Fosse Green Energy Development Consent Order – Deadline 4 Submissions

Planning Inspectorate Case Reference: EN010154

Indicative Layouts

Figure 3-2B SHEET 1

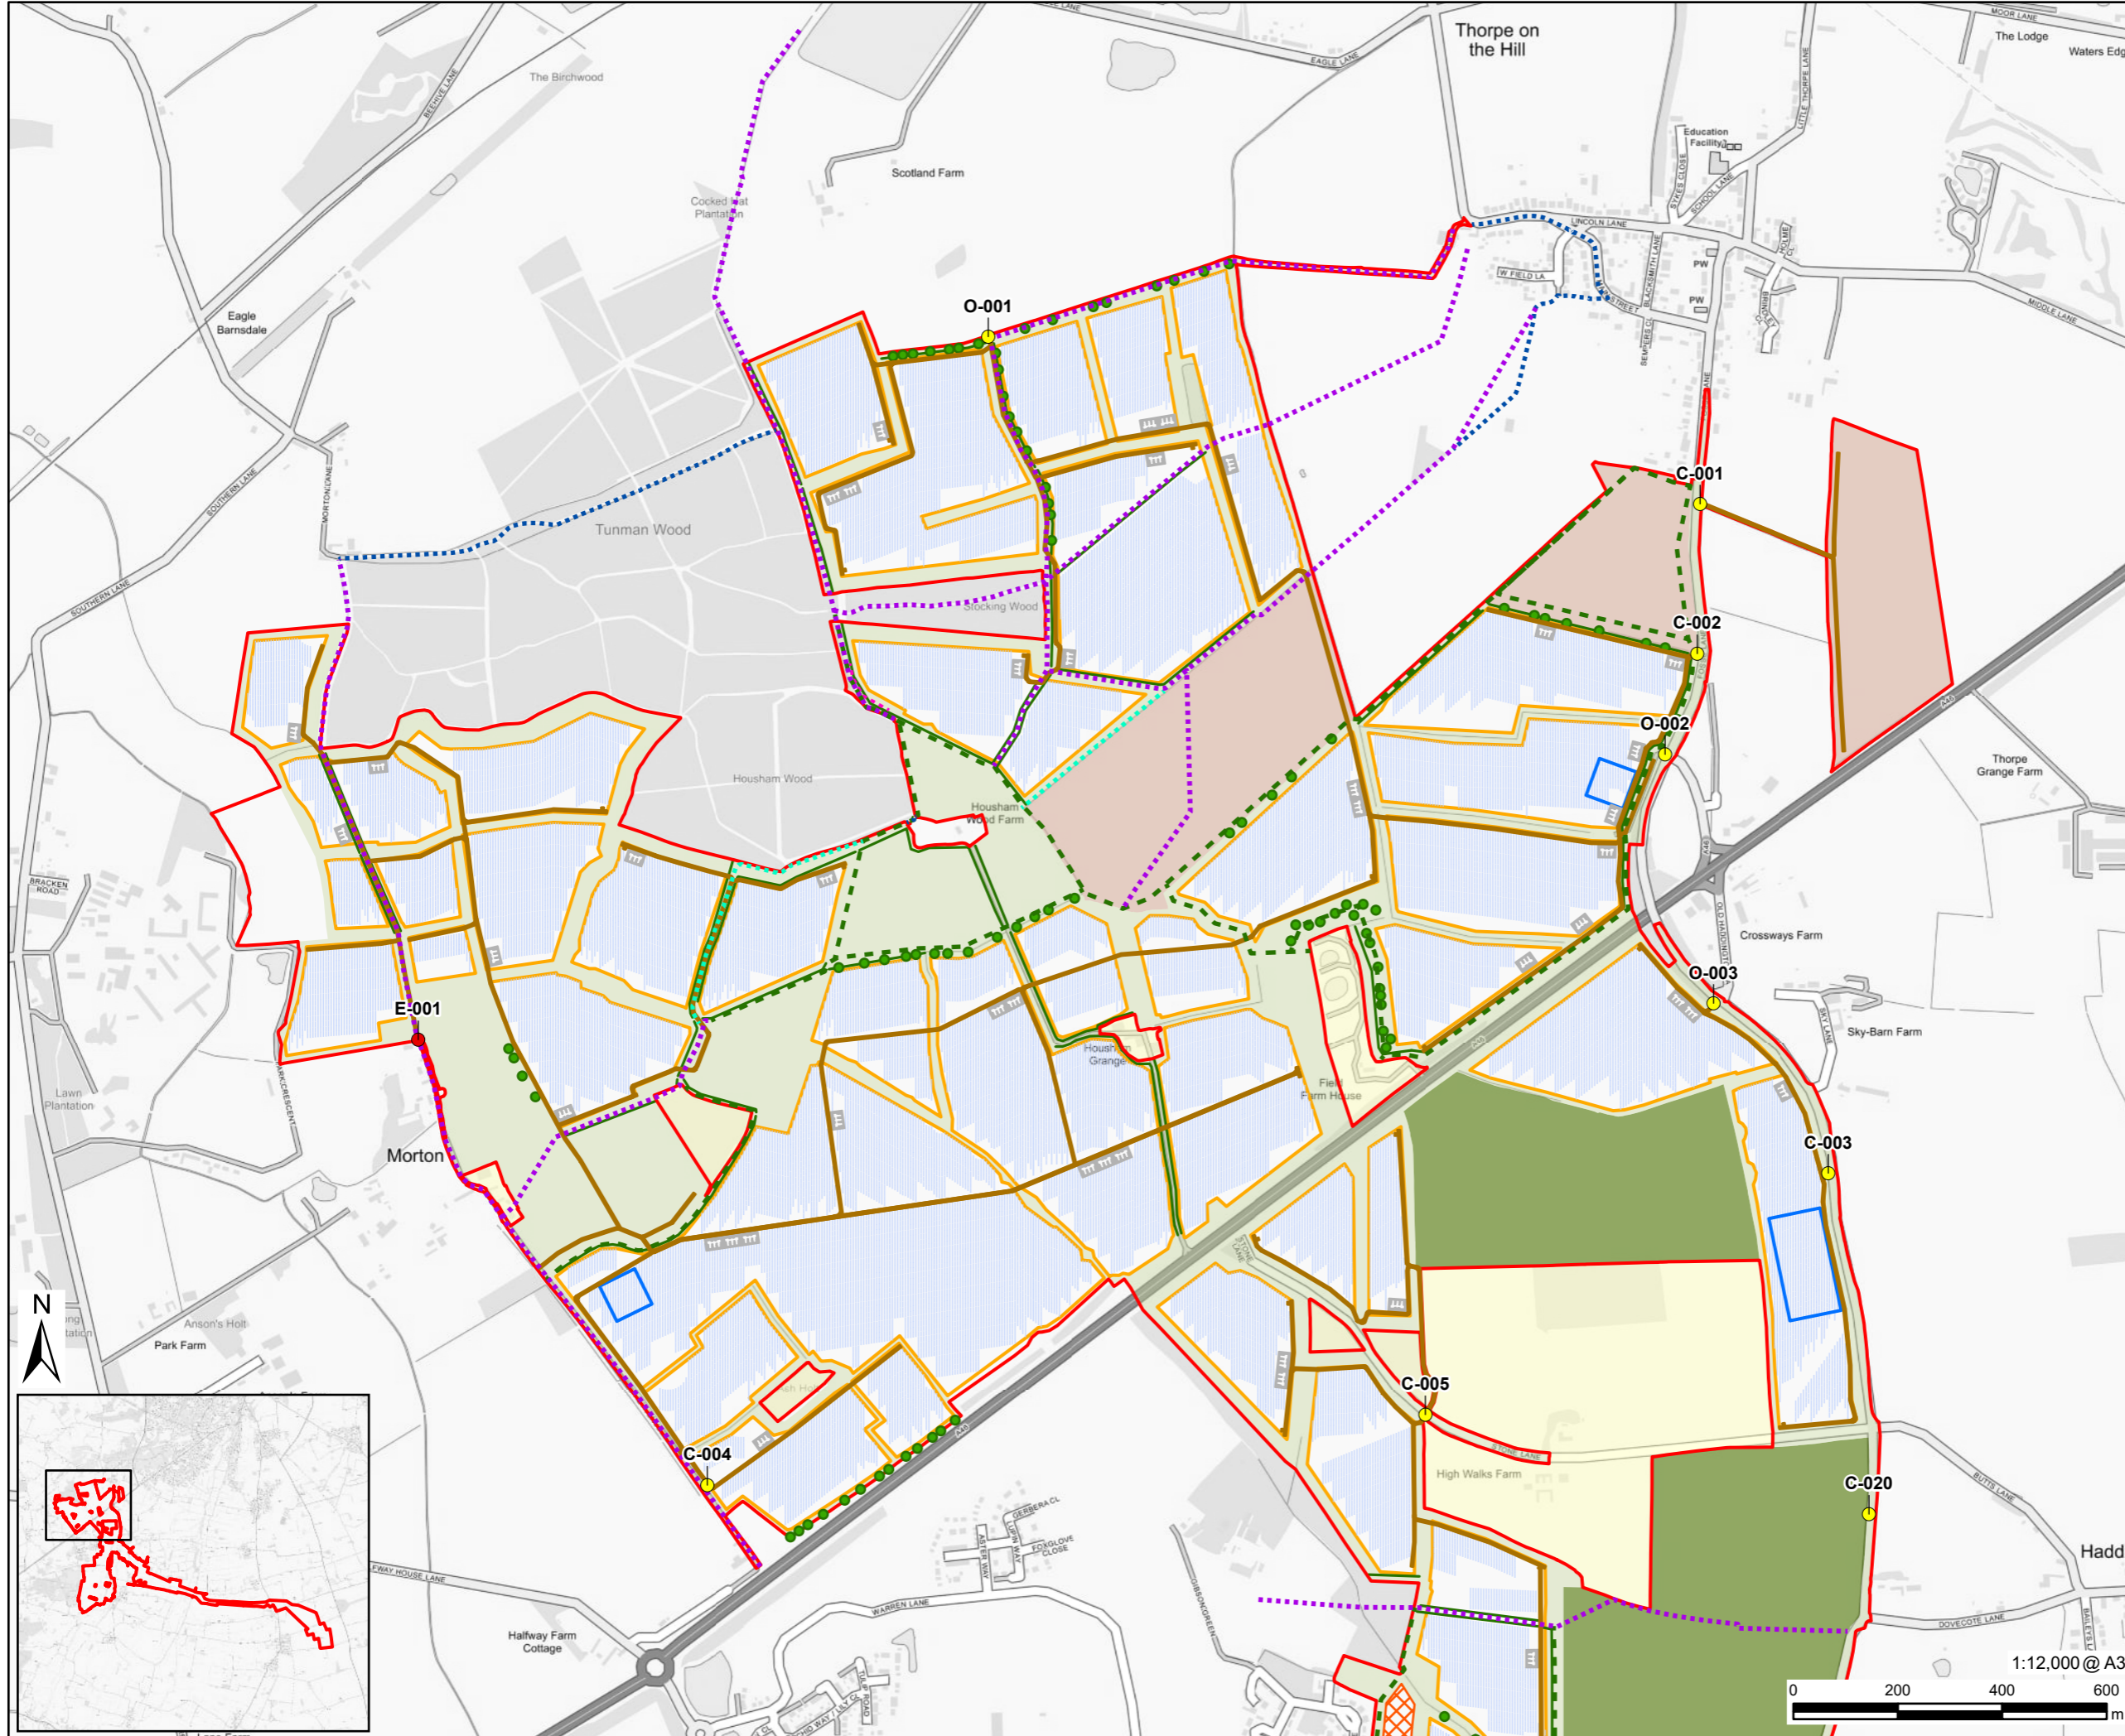
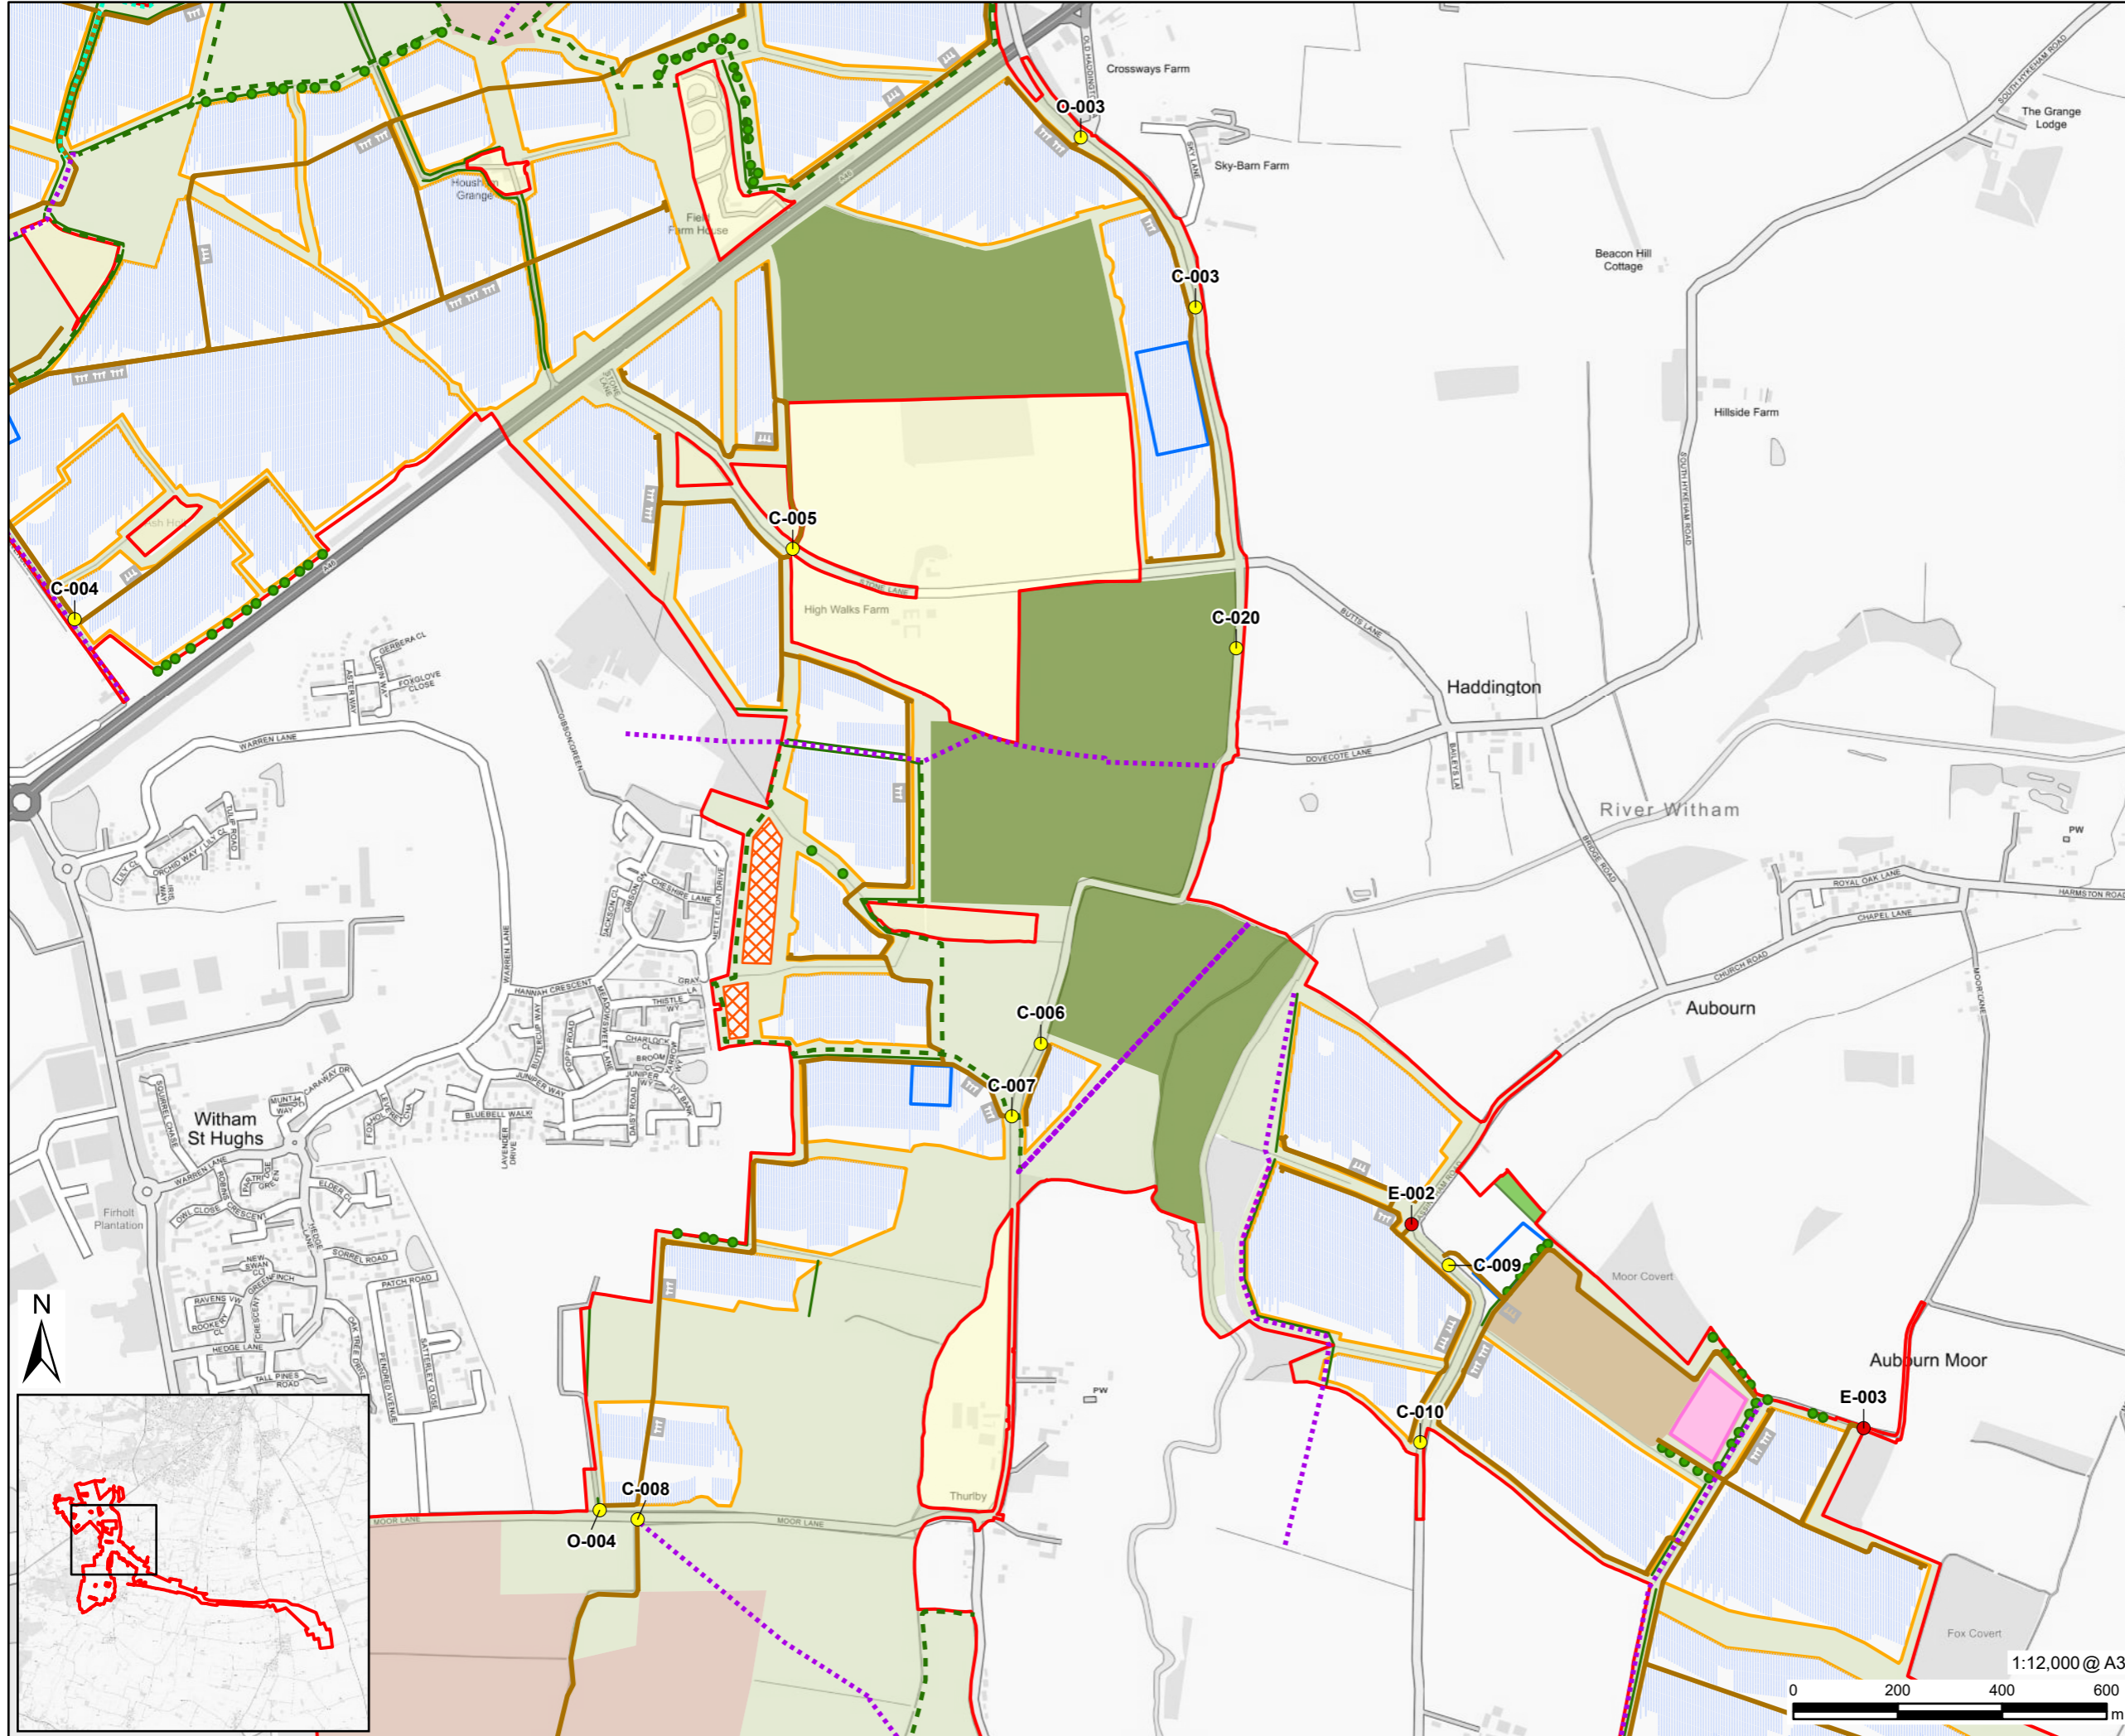
Figure 3-2A 'Indicative Fixed South Facing Layout' and 3-2B 'Indicative Single Axis Tracker Layout' have been updated and submitted as part of the Applicant's Deadline 4 submissions. The update includes additional permissive paths to facilitate the Stepping Out Routes referred to by North Kesteven District Council, enabling these to be walked during the operation of the Proposed Development. These permissive paths will be secured for the lifetime of the Proposed Development. The updates set out in Figure 3-2A and Figure 3-2B are as follows:

- a. A section of the Stepping Out Route to the south of Housham Wood will not be available, with alternative permissive paths provided that are located through grassland or arable fields rather than the existing farm track.
- b. A section of the Thorpe on the Hill Stepping Out Route will not be available, however there is alternative provision via a Public Right of Way.

The Applicant has also taken the opportunity to include within these Figures the changes previously presented in the Landscape Mitigation Plan (at Appendix A of the Framework Landscape and Ecological Management Plan) which formed part of the Change Request **[AS-123]** (the removal of solar in Field 46, the addition of new hedges near River Farm, and clipping of the Order Limits near Thurlby). The total length of the proposed permissive paths following this change is now 10.2km. The total length of the Stepping Out Routes within the Order Limits that are not currently PRow is 1.8km. The net difference is therefore 8.4km.
